## COMMENT RESPONSE NARRATIVE

DATE: June 20, 2023  
PROJECT ARCHITECT: ELEVEN18 ARCHITECTURE, PL  
CONTACT NAME AND NUMBER: Matt Conte, AIA LEED AP | 407-745-5300

PROJECT NAME: **The Springs of Ballentine**  
PERMIT NUMBER:

PLEASE NOTE THE FOLLOWING REVISIONS TO THE PROPOSED SET OF DRAWINGS HAVE BEEN COMPLETED IN RESPONSE TO THE NORTH CAROLINA DEPARTMENT OF HEALTH AND HUMAN SERVICES FOR THE ARCHITECTURAL REVIEW DATED 4/12/2023 AND MEP REVIEW DATED 6/7/2023 AS WELL AS CITY COMMENTS DATE 6/13/2023.

## LIFE SAFETY PLAN

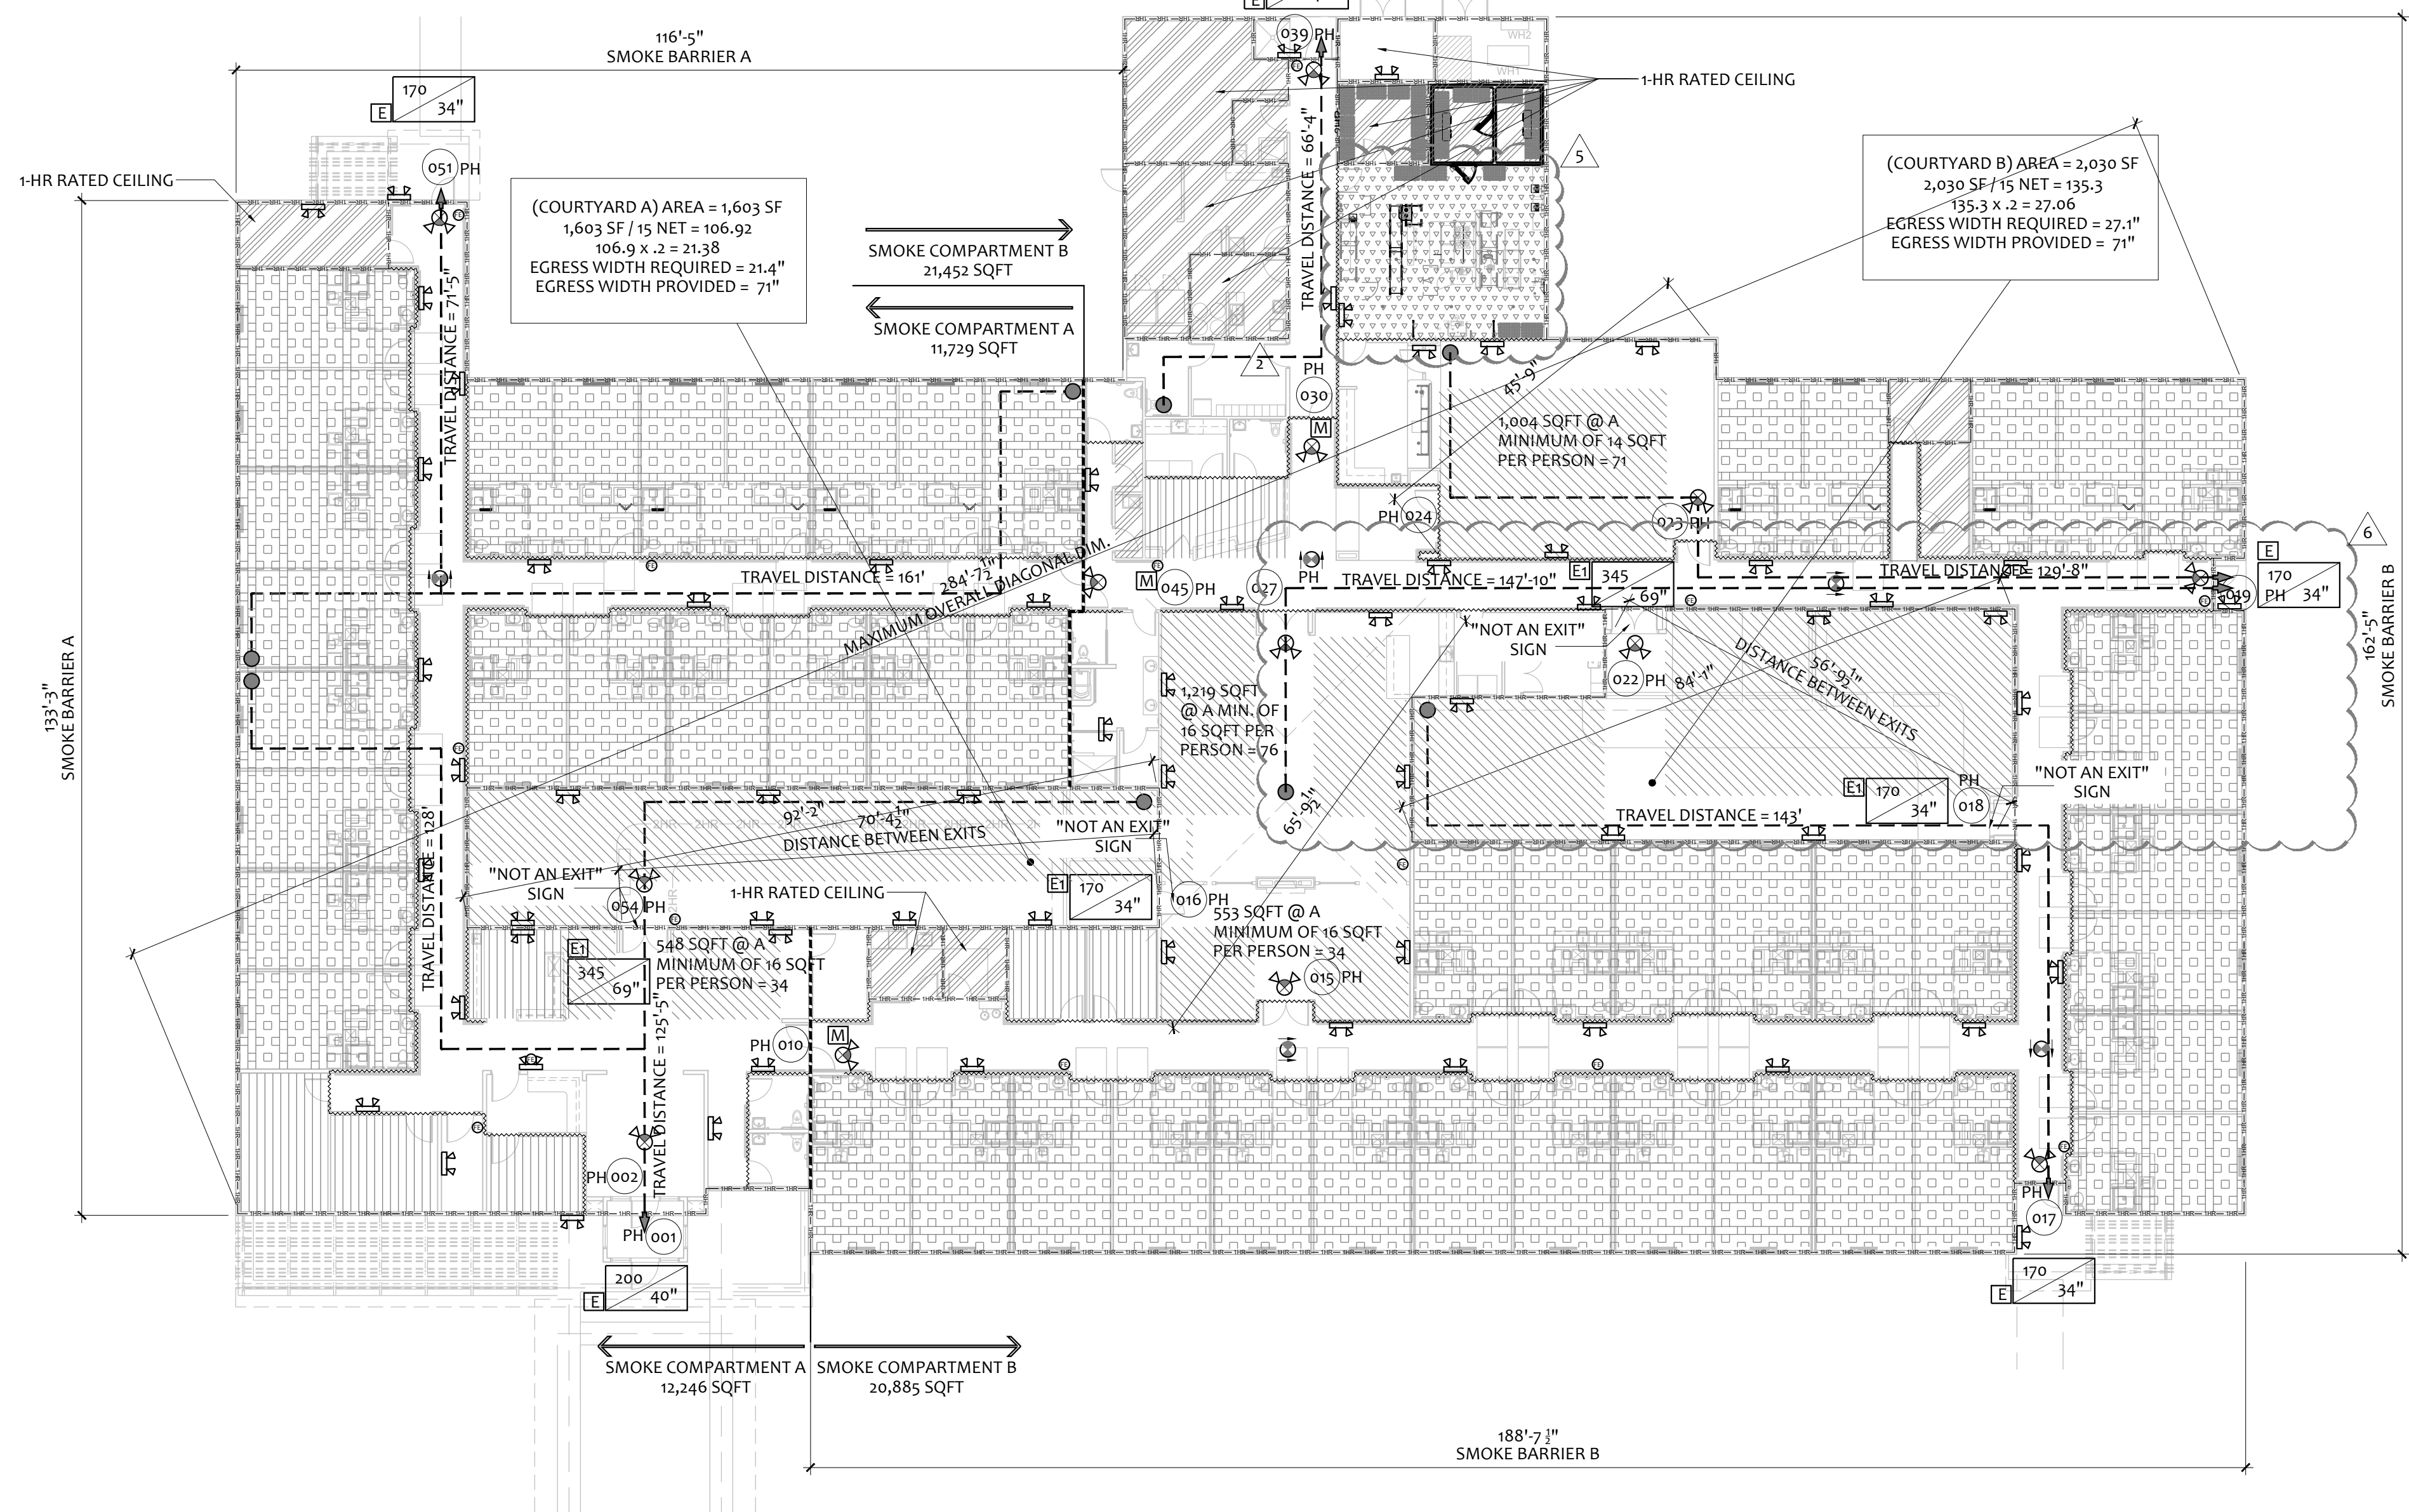
**5. Life safety plan shows room 162 egress exceeds max allowed of 200 feet.**

**RESPONSE:** Room 162 egress path has been updated to be less than 200 ft from an exit on the life safety plan sheet.

**A201**  
 OVERALL FLOOR PLAN

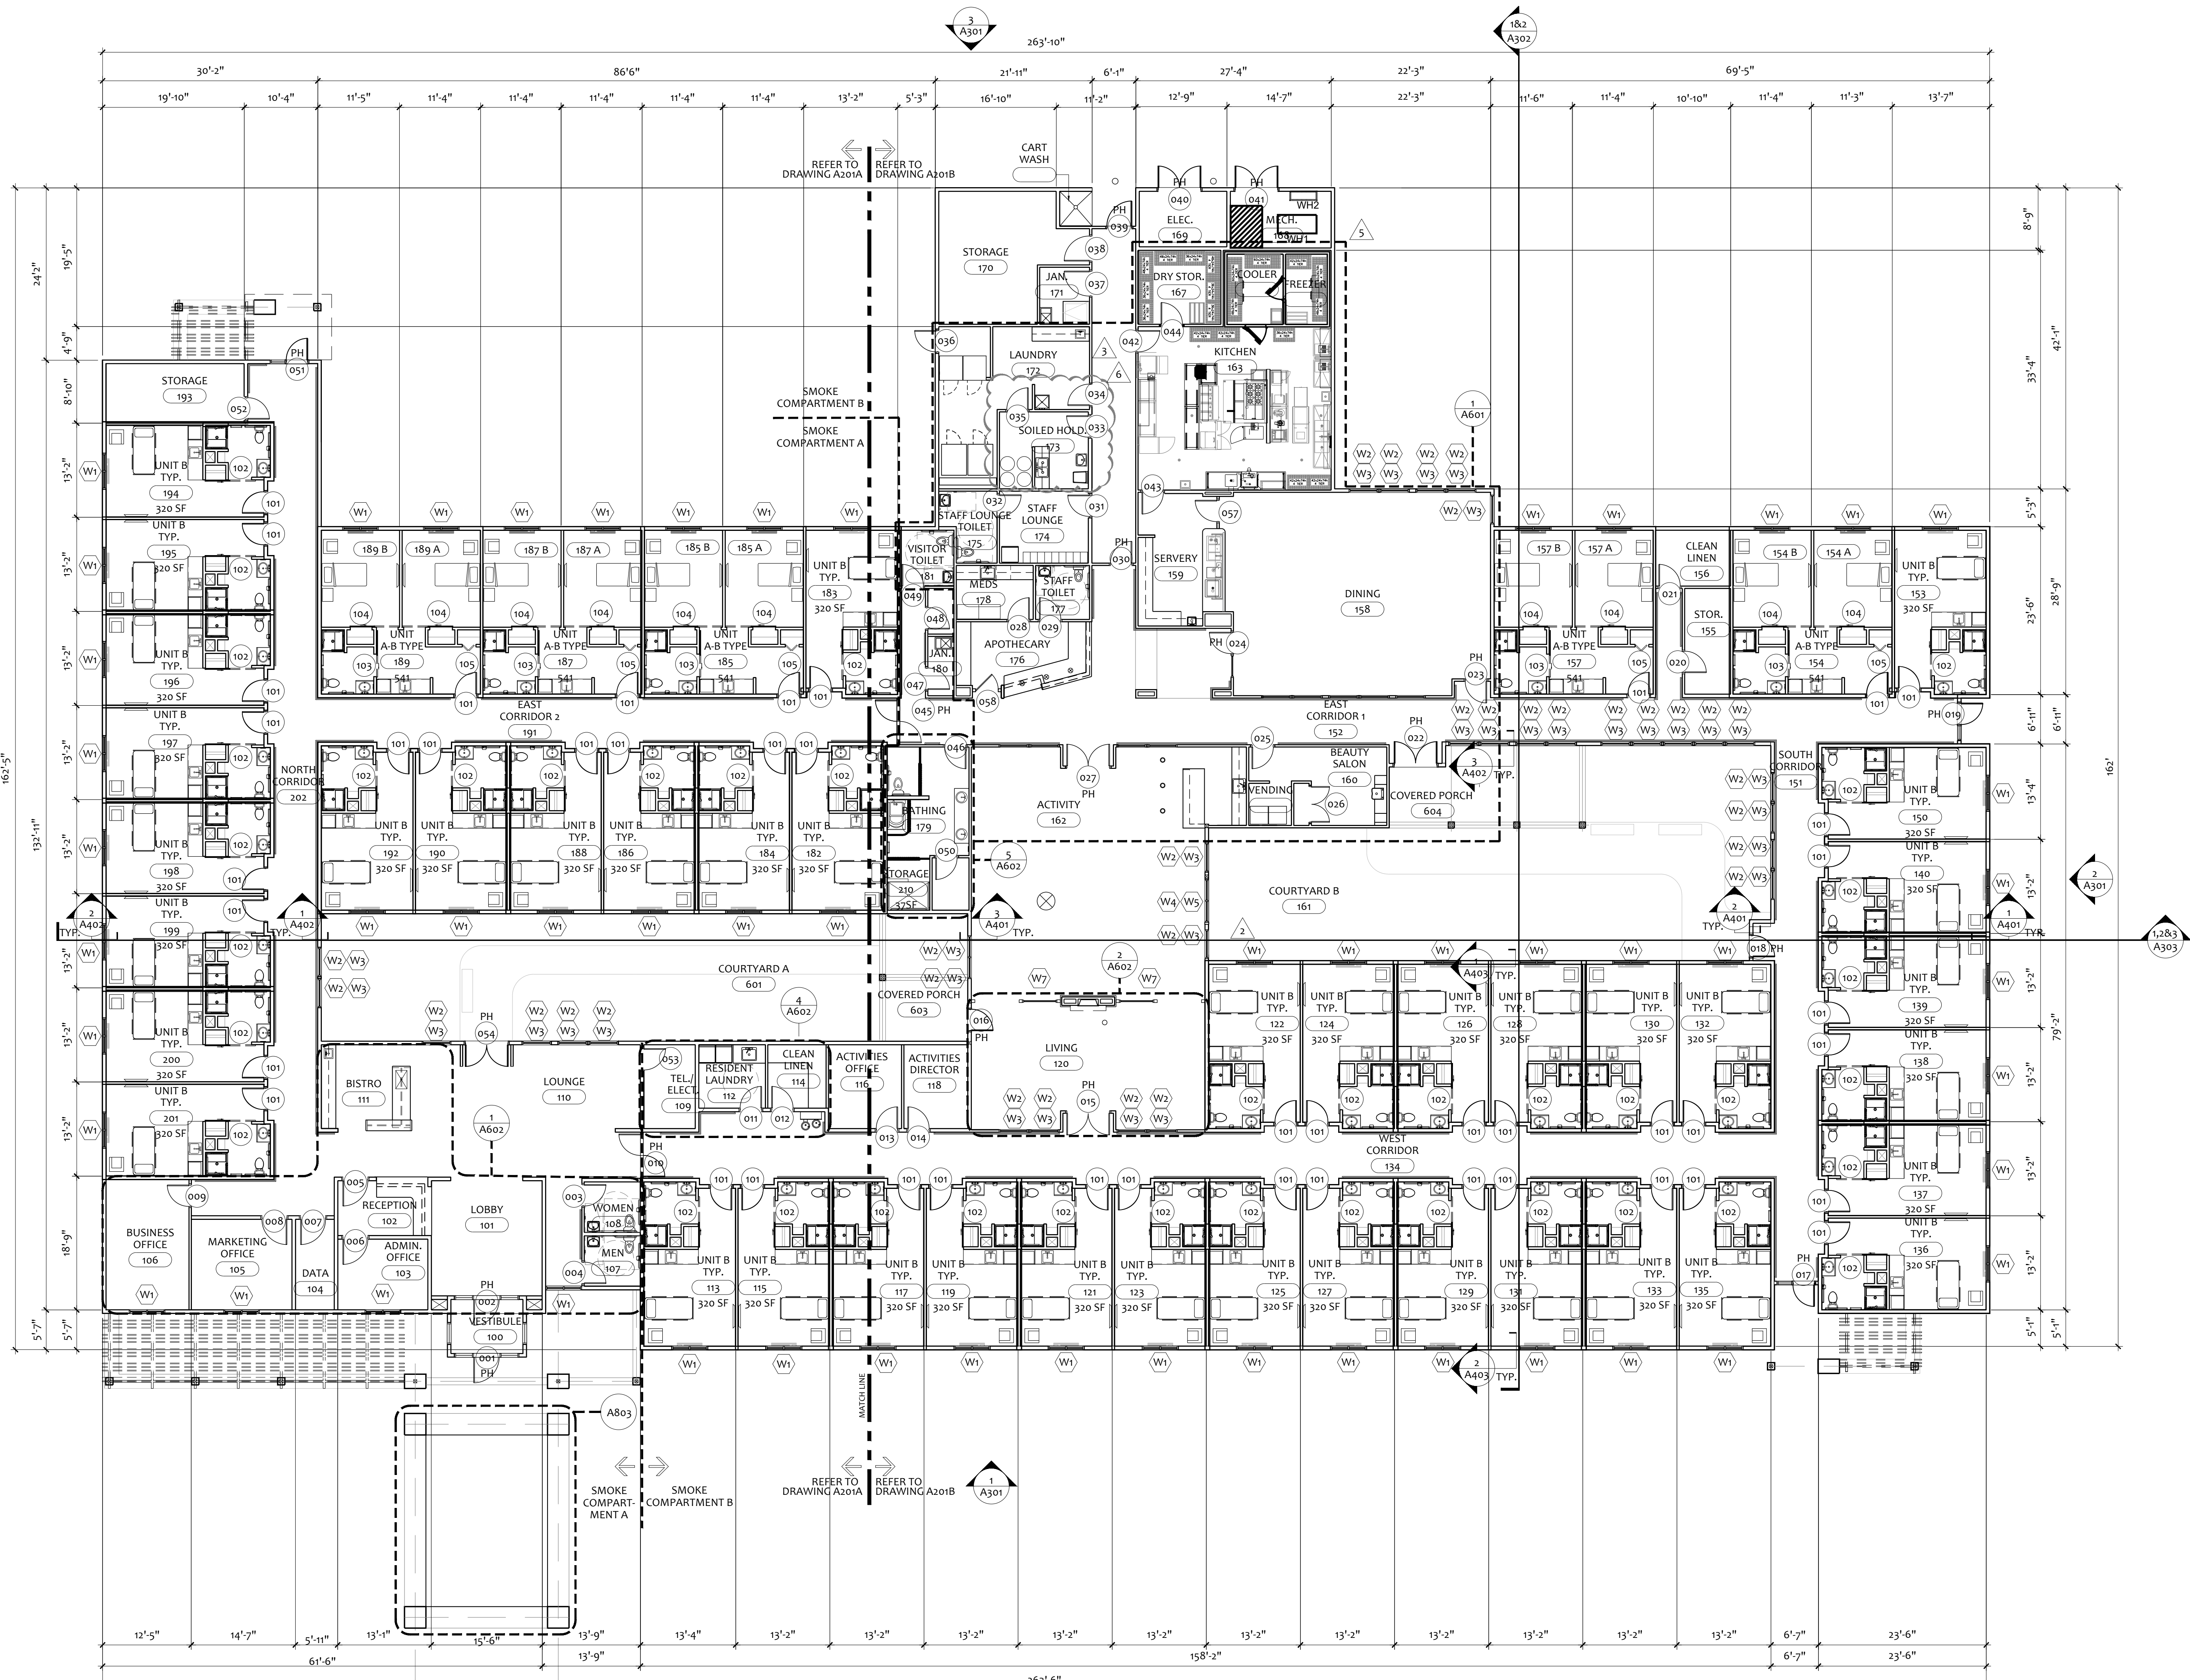
**1. Show the location of the Soiled Utility that is equipped for cleaning and sanitizing bedpans. The plans show two sinks, a flushing sink and hand washing sink, a separate sink from the hand washing sink is required for cleaning and sanitizing of bed pans. [10A NCAC 13F .0305 (J)] An additional (3rd) sink is required for cleaning and sanitizing in addition to the flushing and rinsing sink and the handwashing sink.**

**RESPONSE:** A third sink has been added to the Soiled Utility room (room 173). Refer to revised sheets A201, A203, A601-1 and A606-2 and plumbing.
